CITY OF ALBUQUERQUE

**Re: Townhouses for Worque
12844 Lomas Blvd
Traffic Circulation Layout
Architect's Stamp dated 10-30-16 (K22-D057)**

From: Patz, Logan W.
To: "Roger Cinelli"
Cc: Michel, Racquel M.
Subject: 12844 Lomas, Townhouses for Worque, K22D057
Date: Thursday, November 03, 2016 3:44:00 PM
Attachments: K22D057 No Email TCL BP Cmmt.pdf

1 TRAFFIC CONTROL LAYOUT
Scale: 1" = 20'-0"

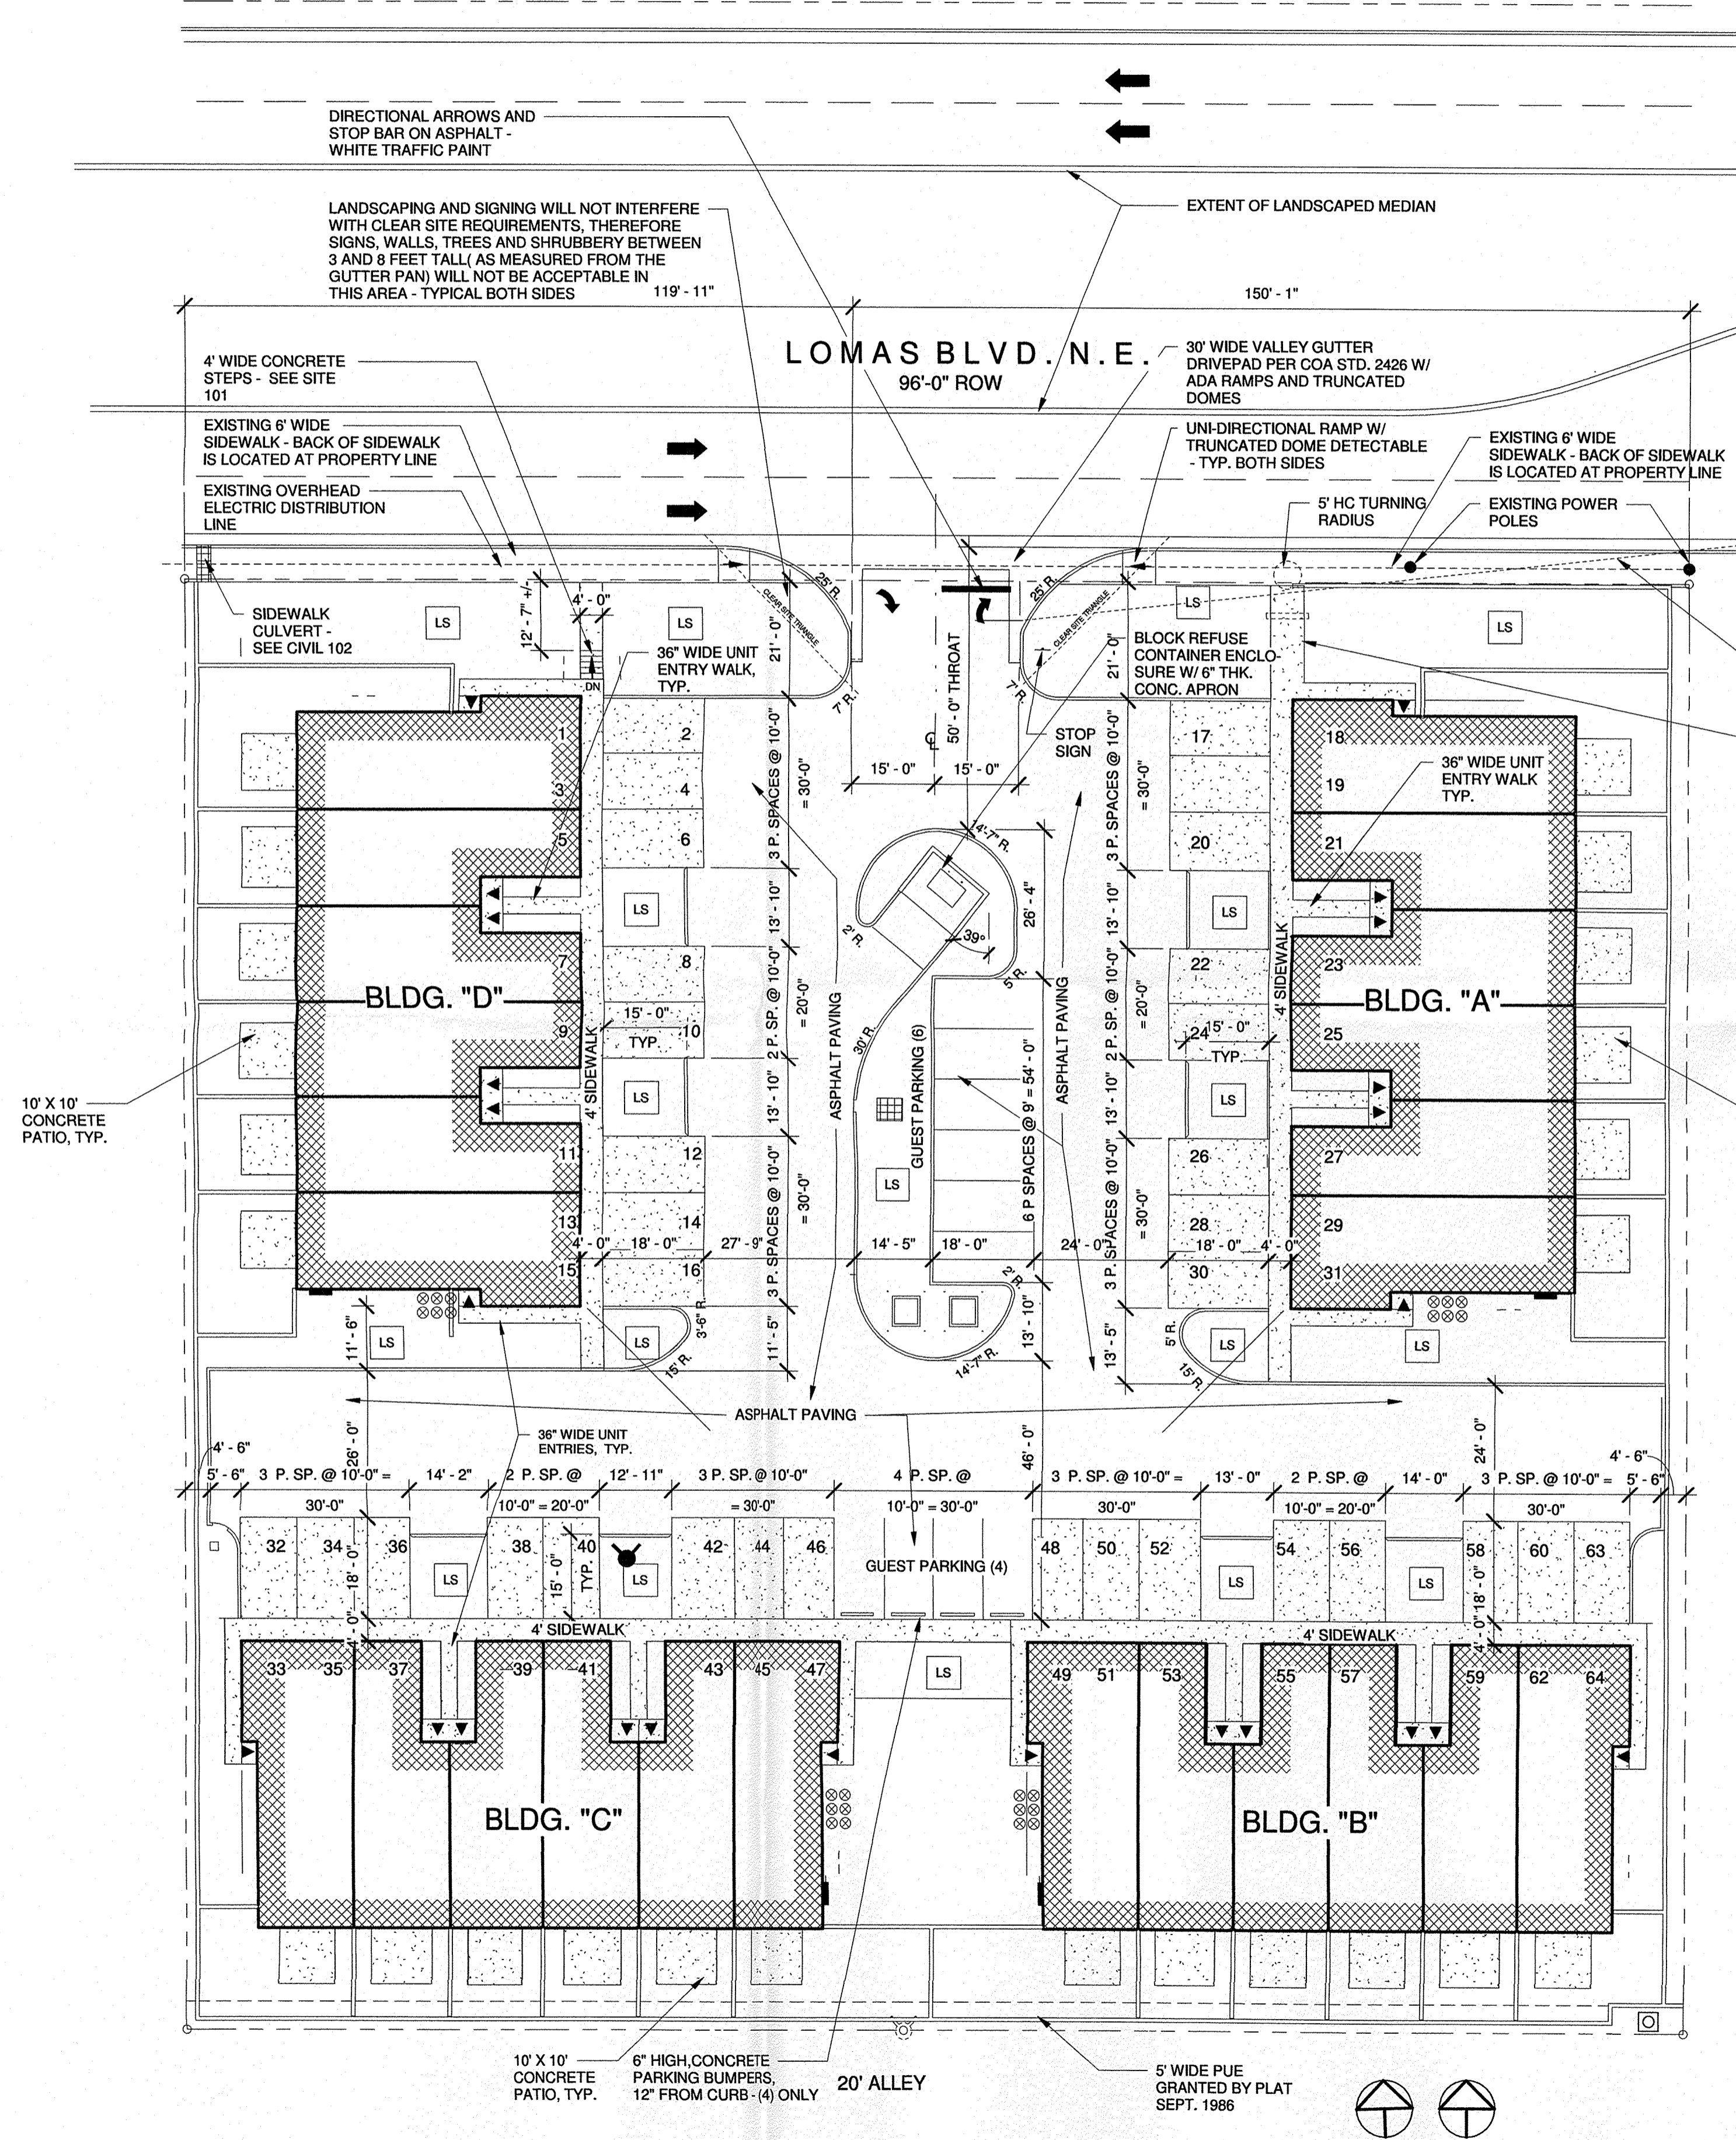
Looking over the TCL there is two items that need to be addressed.

- First the unidirectional ADA curb ramps should be 6' in width to match the sidewalk widths and the truncated domes should span the whole width of the landing and are 2 feet wide.
- Please provide a detail and dimensions for the recessed curb bump-outs
